DECISION DELEGATED TO HEAD OF PLANNING

Application No: H17-0167-24 **Applicant:** Mr & Mrs S Huntsman

Proposal: Proposed Dwelling - approved under H17-0873-18. Modification of Condition 2 to allow amendments to previously approved plans

Location: 72 Reservoir Road Surfleet Spalding

PROPOSED ELEVATIONS

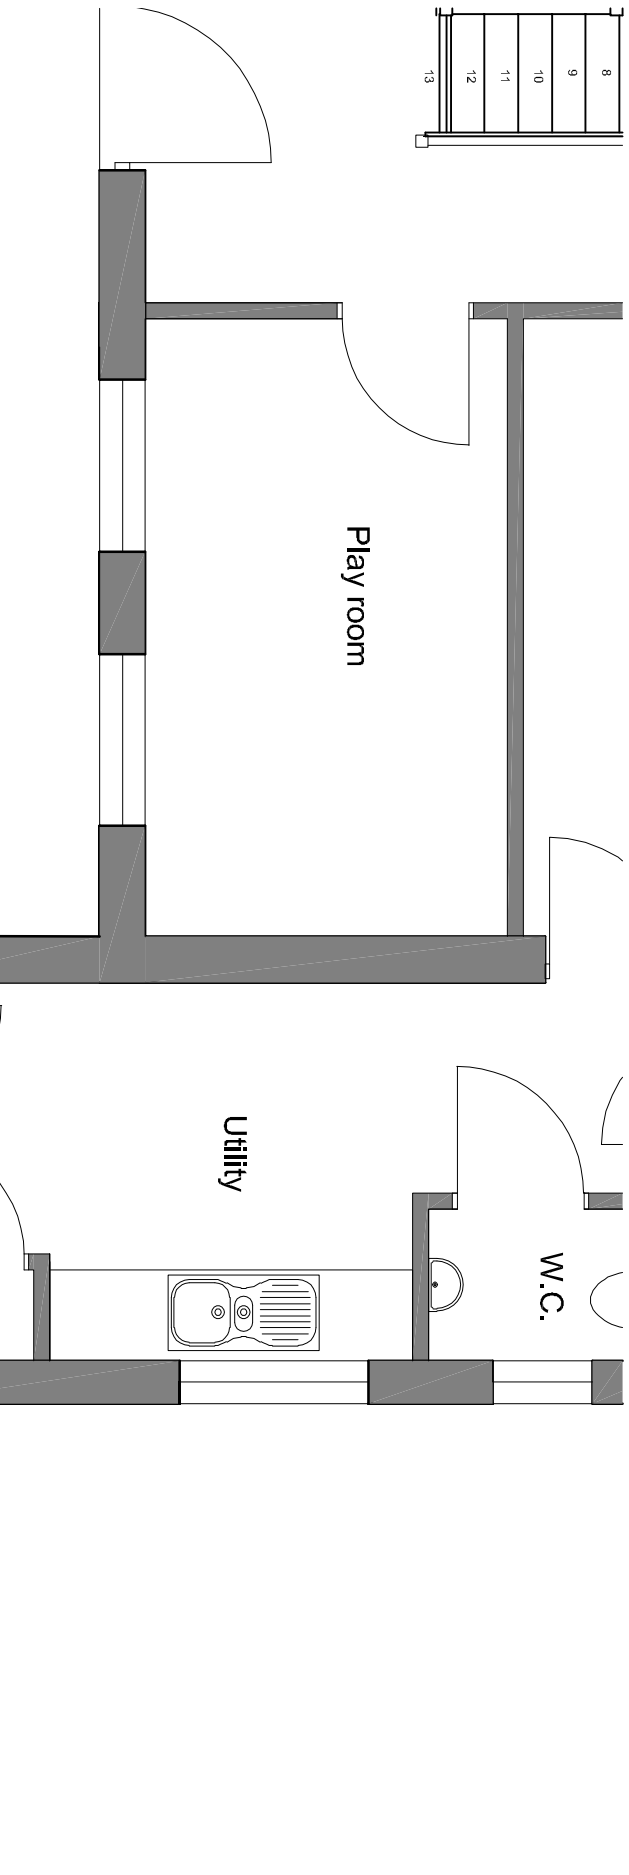
The proposed amendment to the garage design is considered to have a material impact on the character of the site and surrounding area. The applicant has stated that the amended plans are no closer to 74 Reservoir Road. *"Just slightly taller"*. The eaves height is 60% higher at 3.84 metres than the previously approved height of 2.4 metres. The ridge height is 27.6 % higher at 6.51 metres than the previously approved height of 5.1 metres. Additionally the length of the garage projection is 79.5% larger at 10 metres than the previously approved length of 5.57 metres. This is a material rise in the height and massing of the garage projection. These new dimensions are considered to create a projection at scale that is akin to a two bedroom new build dwelling, sited only 4.02 metres from the highway.

The design of the south facing first floor window of the study is considered to be out of keeping with the fenestration of the remainder of the dwelling. Whilst it is appreciated that the window design maximises natural light, no attempt has been made to relate the design to existing fenestration

The proposal is considered to generate a material overshadowing impact on the dwelling at 74 Reservoir Road to the east of the site. The eaves height is 60% higher at 3.84 metres than the previously approved height of 2.4 metres. The ridge height is 27.6 % higher at 6.51 metres than the previously approved height of 5.1 metres. Additionally the length of the garage projection is 79.5% larger at 10 metres than the previously approved length of 5.57 metres. This is a material rise in the height and massing of the garage projection.

Due to the orientation of the fenestration on the garage / study building, as well as the adjacent boundary treatment, there is not considered to be a material overlooking impact on adjacent dwellings. Aside from the garage doors and access door, there is no other fenestration at ground floor level. These doors face the western boundary which is bordered by a 1.2 metre high close boarded fence with established trees and hedging beyond. This trees and hedging is not subject to a preservation order, therefore, if they were to be removed there is not considered to be a material overlooking impact from the ground or first floor west facing fenestration as they face the frontage of the site, which is largely visible from the highway at Reservoir Road. The first floor rooflight on the east facing roofslope serves a wc and is expected to be obscure glazed. This rooflight is approximately 1 metre above floor level. It is considered that this window should be limited opening to prevent a material overlooking impact to 74 Reservoir Road if opened.

PROPOSED BLOCK PLAN

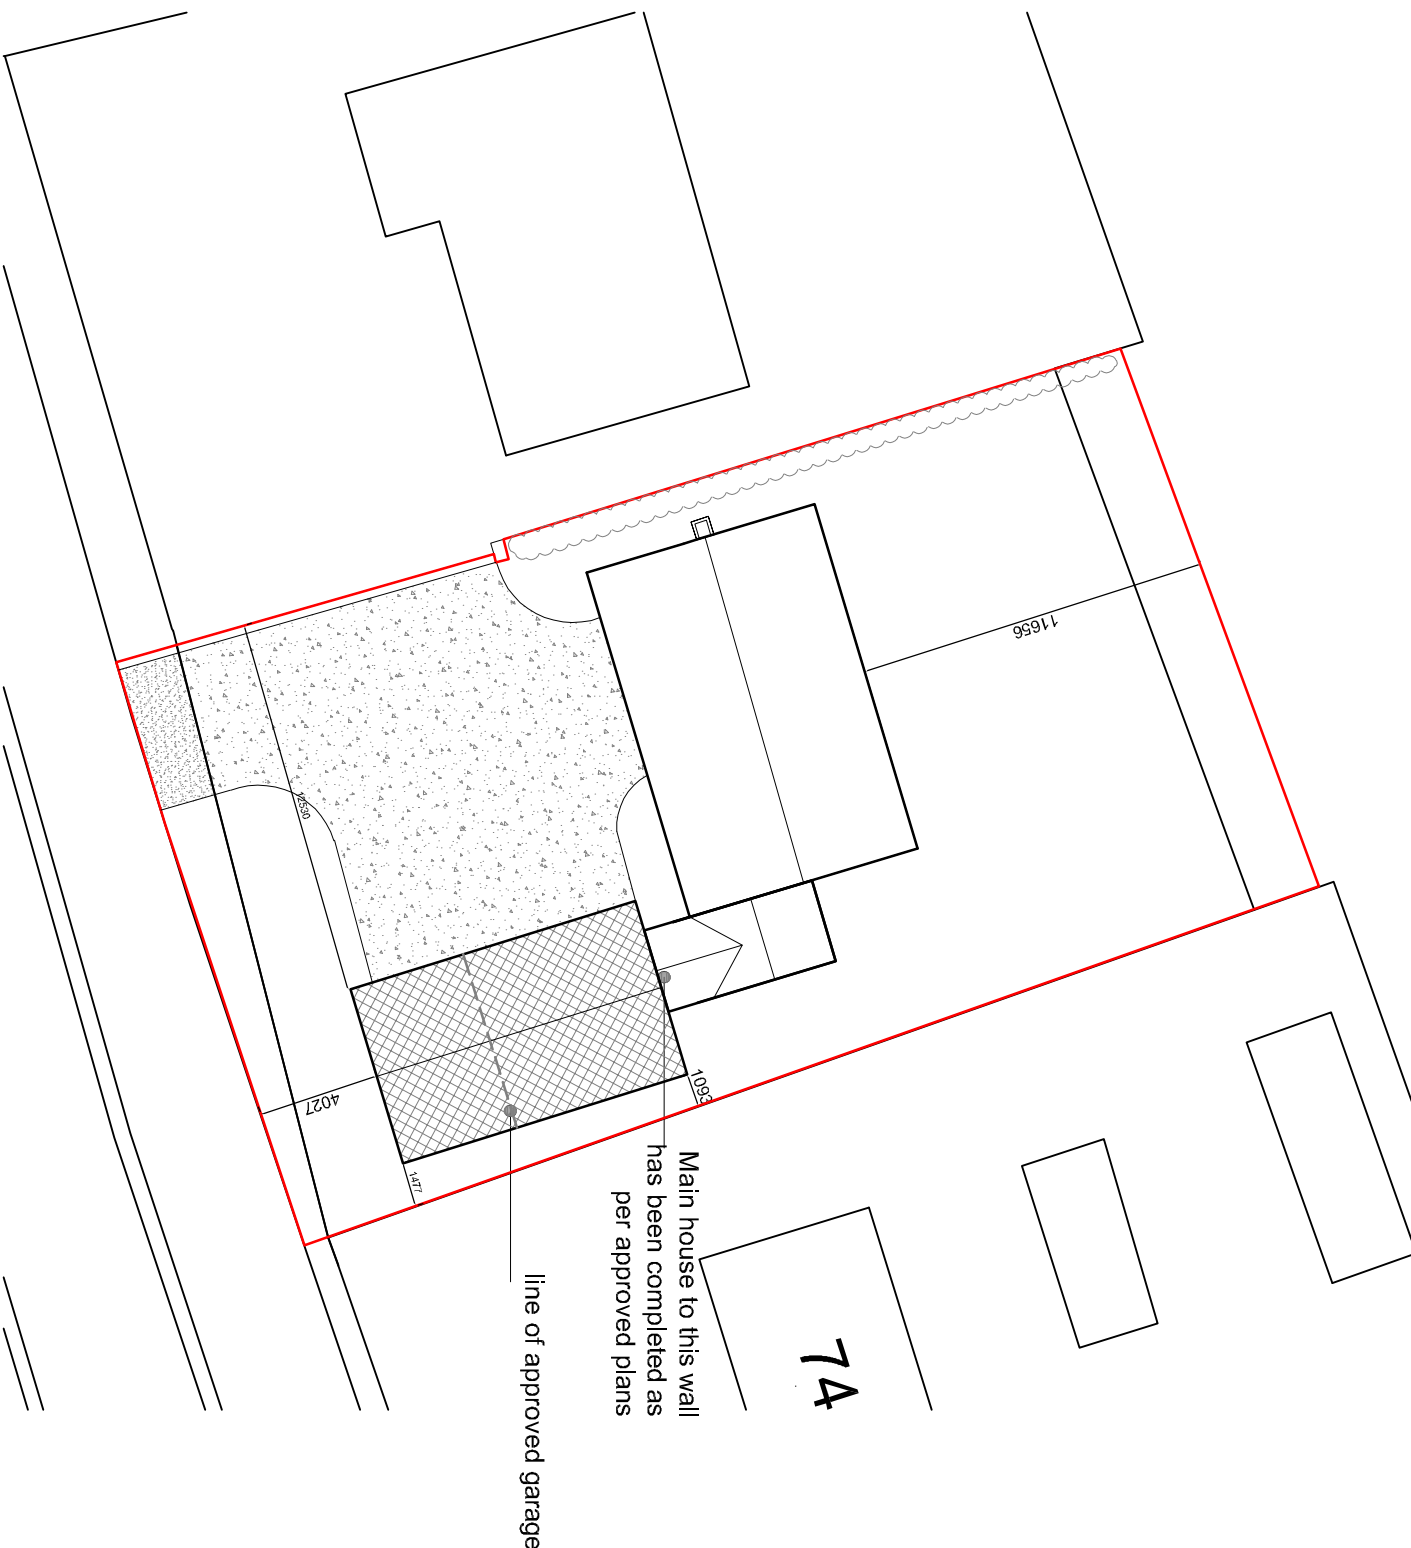
The proposed garage would be sited 1.093 metres from the eastern boundary at the nearest point, 4.027 metres from the southern boundary and 12.53 metres from the western boundary. The garage has an eaves height of 3.84 metres and a ridge height of 6.51 metres. The proposed footprint measures 10 metres in length and 6.06 metres in depth. Two dormer windows are sited on the west facing roofslope, with a rooflight on the east facing roofslope. An entrance door will be sited on the western elevation. An alcove will be sited to the rear of the garage building to house a repositioned air source heat pump. Brick and tile is to match that of the previous approval.

The new dimensions of garage / office projection would create a material development precedent in the vicinity of the site by allowing a visual prominent two storey development adjacent to the highway that is sited significantly forward of other lines of frontage in the vicinity of the site.

The proposal is considered to constitute overdevelopment of the front of the site. The overall height of the garage is 27.6% higher than the previous design and 79.5% larger in length. This proposal is considered to material visual impact on the surrounding area, by positioning development significantly forward of the line of frontage of properties to the east and west of the site.

The submitted plans also show a "repositioned" air source heat pump. No previous applications have shown an air source heat pump on any plans. The air source heat pump is already present on site adjacent to the eastern boundary. There are noise concerns with regards to this pump and no further information has been submitted to justify it's location or details as to noise generated by the appliance.
